Planning Application Ref: **AW/250/19/HH**

Location: **19 Kingsway, Aldwick, PO21 4DQ**

Description of works: **Extension to driveway to front & widening driveway gate. This application affects the character & appearance of the Craigweil House Conservation Area**

Proposed

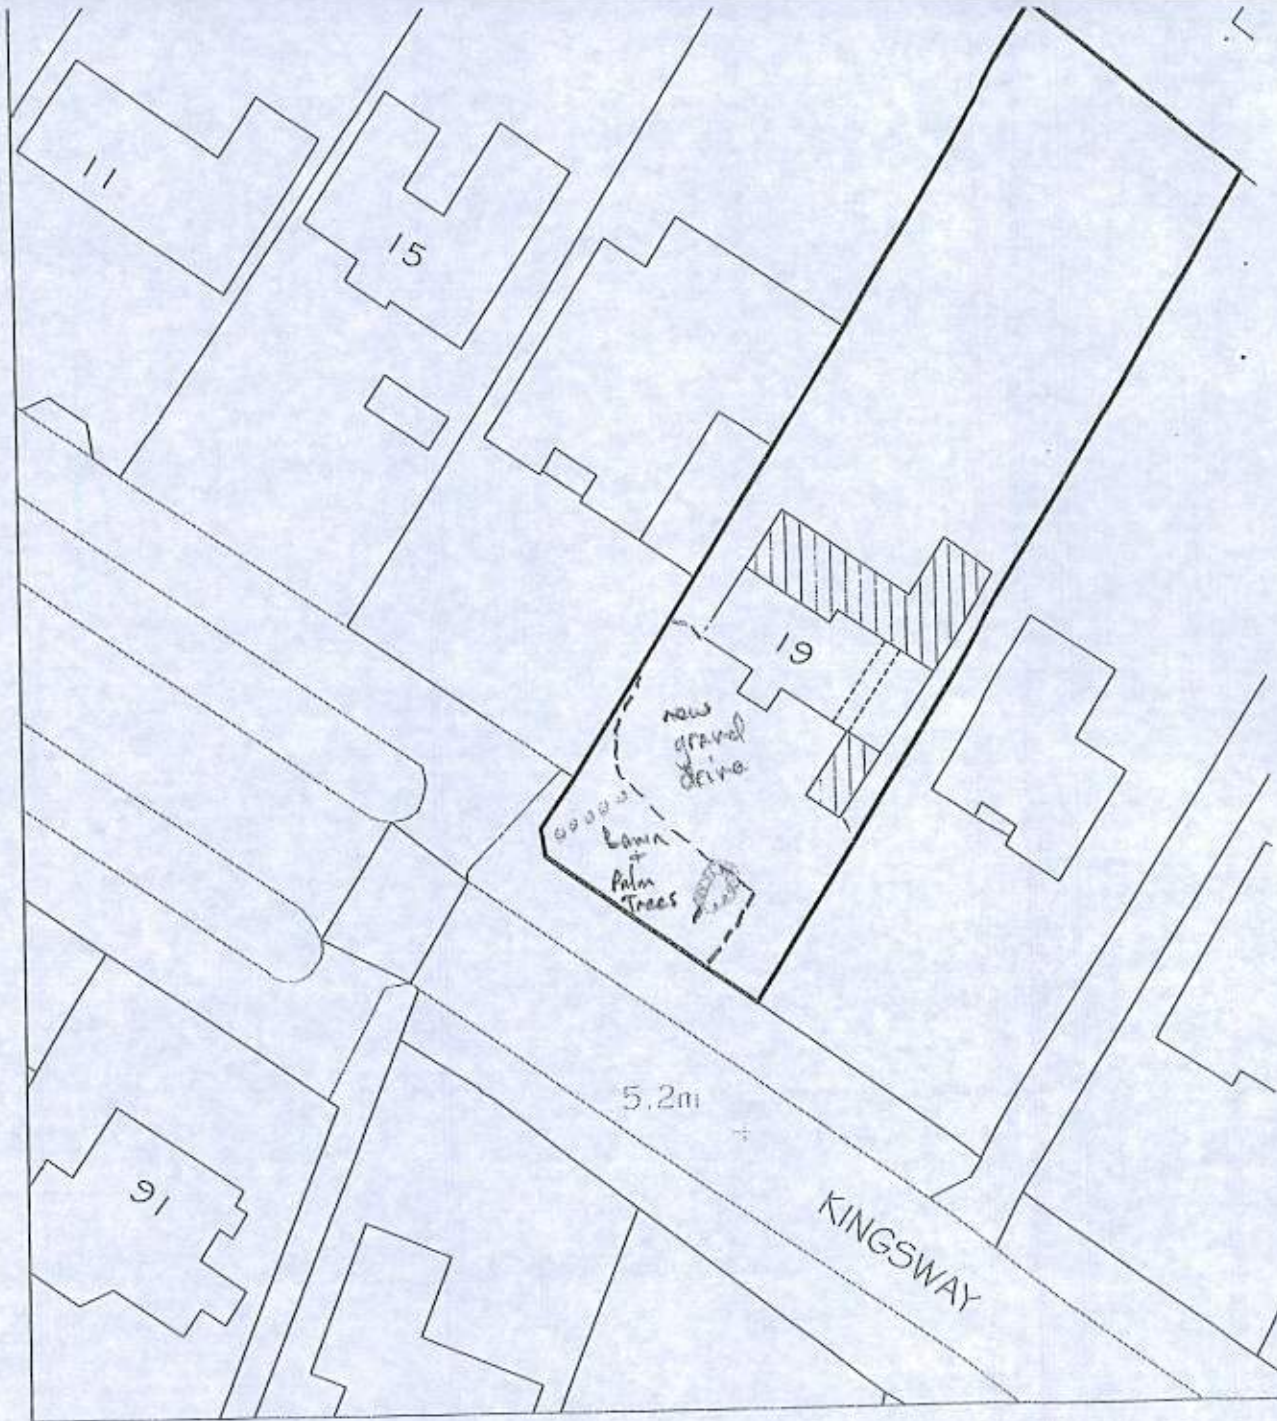
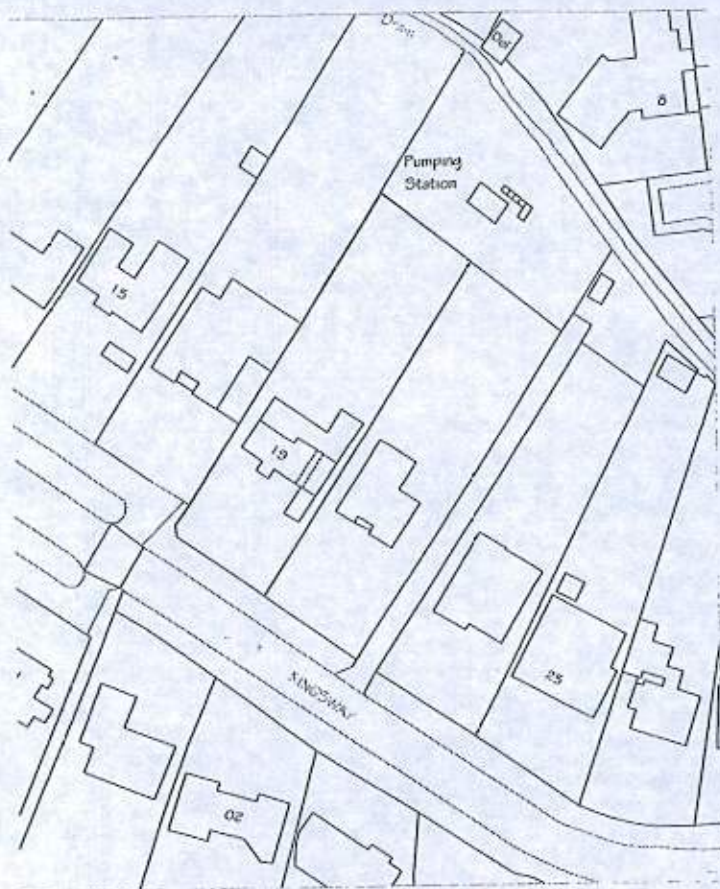
- There is a sketch plan (illustrative only) and insufficient engineering detail in support of this proposal; to be able to determine the full extent of its impact on trees, both above and below ground level. One can only assume the existing driveway width (between the garage and garden/verge interface) is to be retained as it is. Whilst welcome, we must understand how the existing construction is to be demolished, the new installation applied, and the type of materials to be used. There is also the installation of border sleepers to consider and preparation of shrub borders/planting within the nominal root protection area (RPA) of significant trees. All these concerns should be properly addressed within a detailed arboricultural report and to our satisfaction.
